**WELWYN HATFIELD BOROUGH COUNCIL
EXECUTIVE DIRECTOR - PLANNING, PUBLIC PROTECTION AND GOVERNANCE**

DELEGATED APPLICATION

Application No: 6/2021/1508/HOUSE
Location: Just House Coopers Lane Northaw Potters Bar EN6 4NJ
Proposal: Installation of an external swimming pool.
Officer: Ms Kelsey Collins

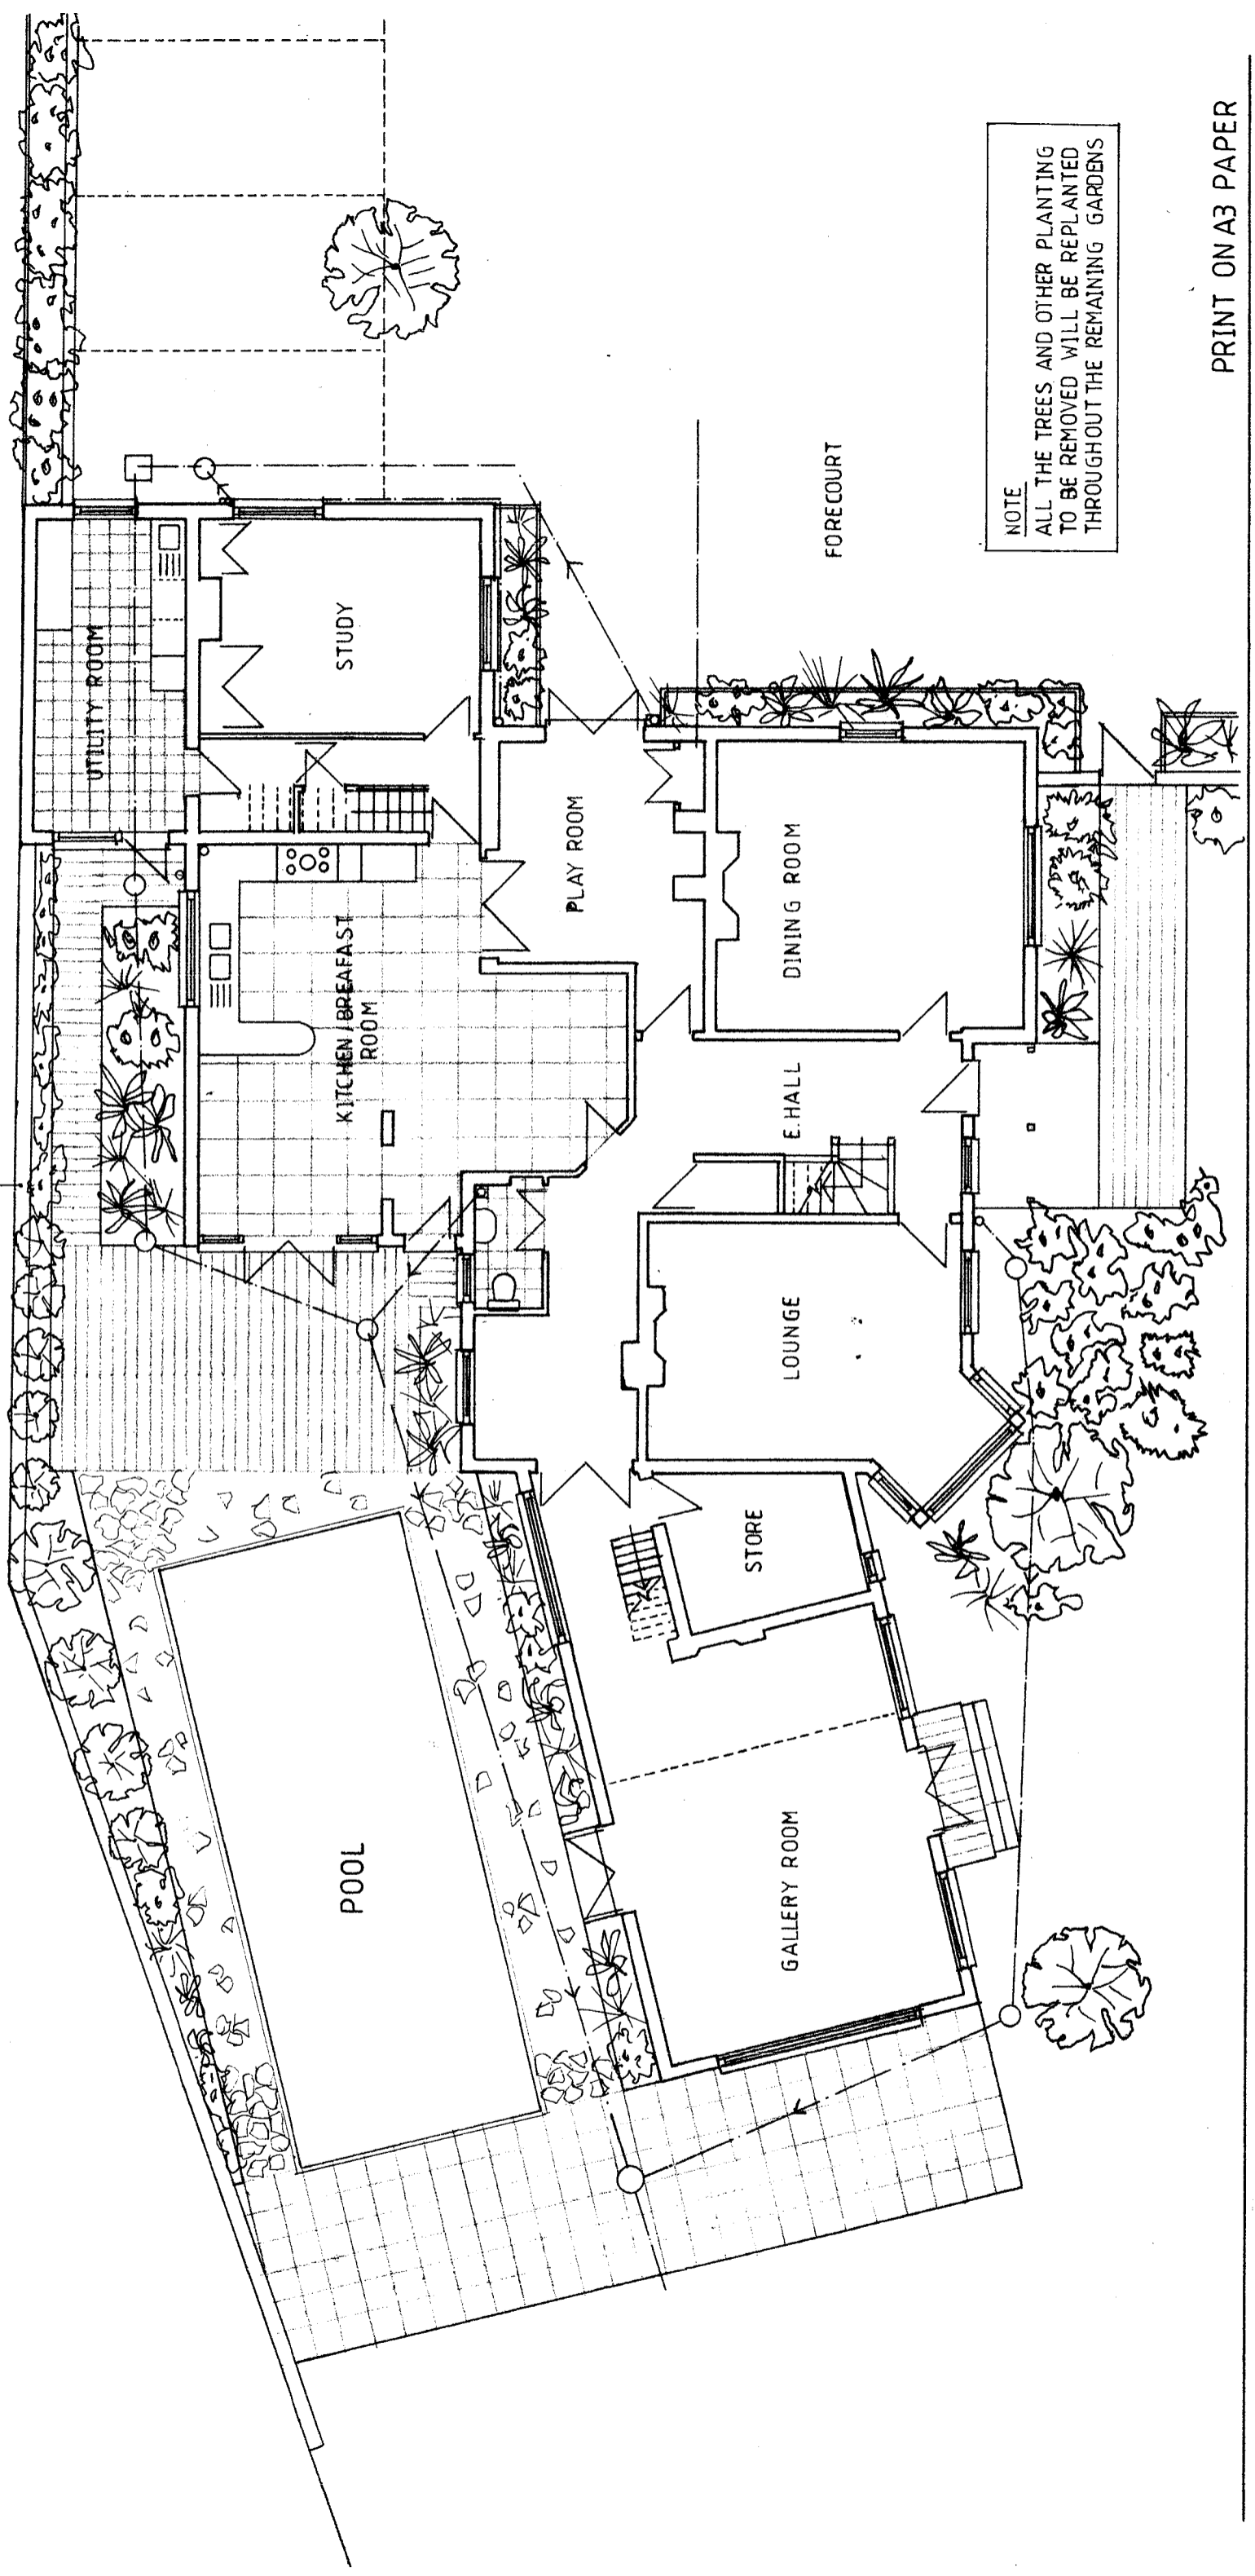
No elevation drawings have been provided, however, annotation on Drawing No. AR/A3/006A confirms that “the edge of the pool to be at the existing ground level and the pool itself below ground”. Therefore, whilst the swimming pool would have a relatively large footprint adding to the developed area within the curtilage of the host dwelling, it would not add any volume above ground level.

The Gardens Trust raised concerns that there may be overall loss of tree cover, none of the trees on the site are covered by a TPO, and drawing number AR/A3/006 states that all trees and planting to be removed will be replanted throughout the garden, and taking on board the Built Heritage Consultant comments a condition securing further planting details is considered appropriate.
